272-274 Parkdale Avenue

MEMO

TO: Wally Dubyk, Transportation Project Manager – Transportation Approvals
FROM: Adam Howell, P.Eng.
SUBJECT: 272-274 Parkdale Avenue – Screening Form Explanation
DATE: March 15, 2023

COMMENT AND RESPONSE LOG

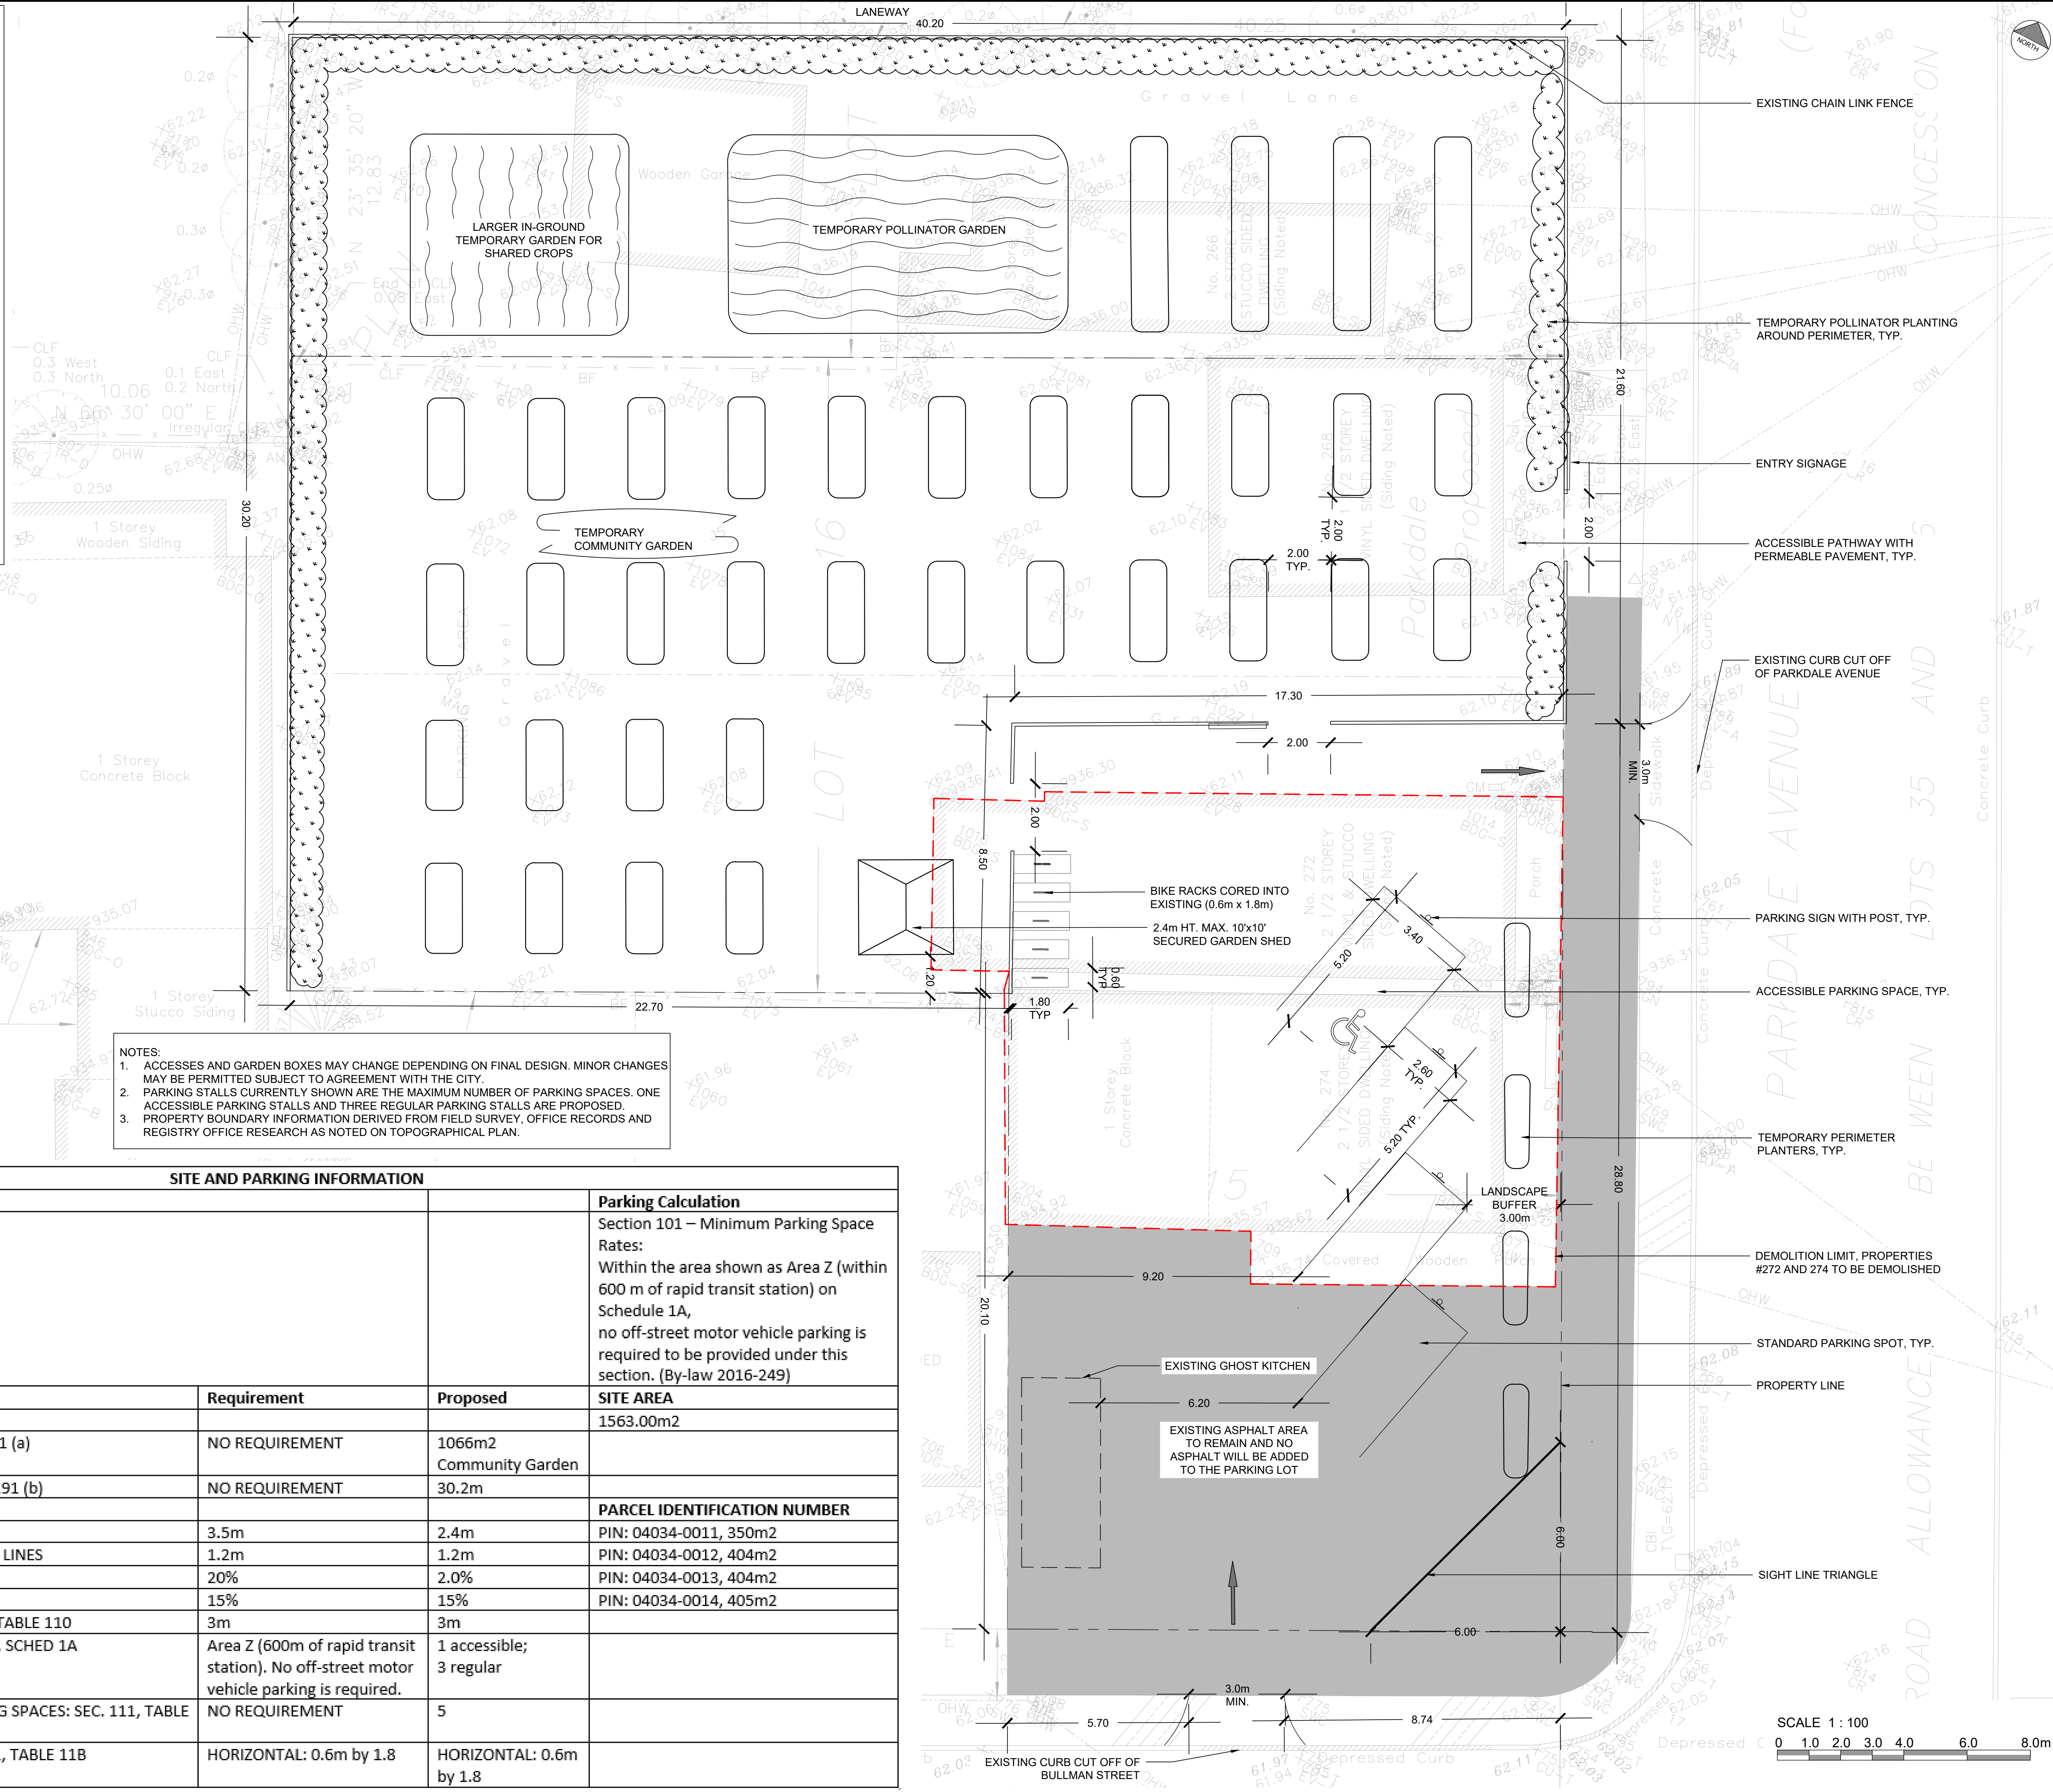
Thank you, no conveyance is being provided with this application.
- 4 The City of Ottawa Zoning By-Law Corner Sight Triangles (Sec. 57) states that no obstruction to the vision of motor vehicle operators higher than 0.75 metres above grade. The consultant should review the sight distance to ensure that no obstructions hinder the view of the driver at the Parkdale Avenue and Bullman Street intersection.

The Corner Sight Triangle has been added to the site plan in Appendix C. There are no obstructions for drivers on Parkdale Avenue and Bullman Street.
- 5 Permanent structures such as curbing, stairs, retaining walls, parking spaces and bicycle parking racks are not to extend into the City’s right-of-way limits.
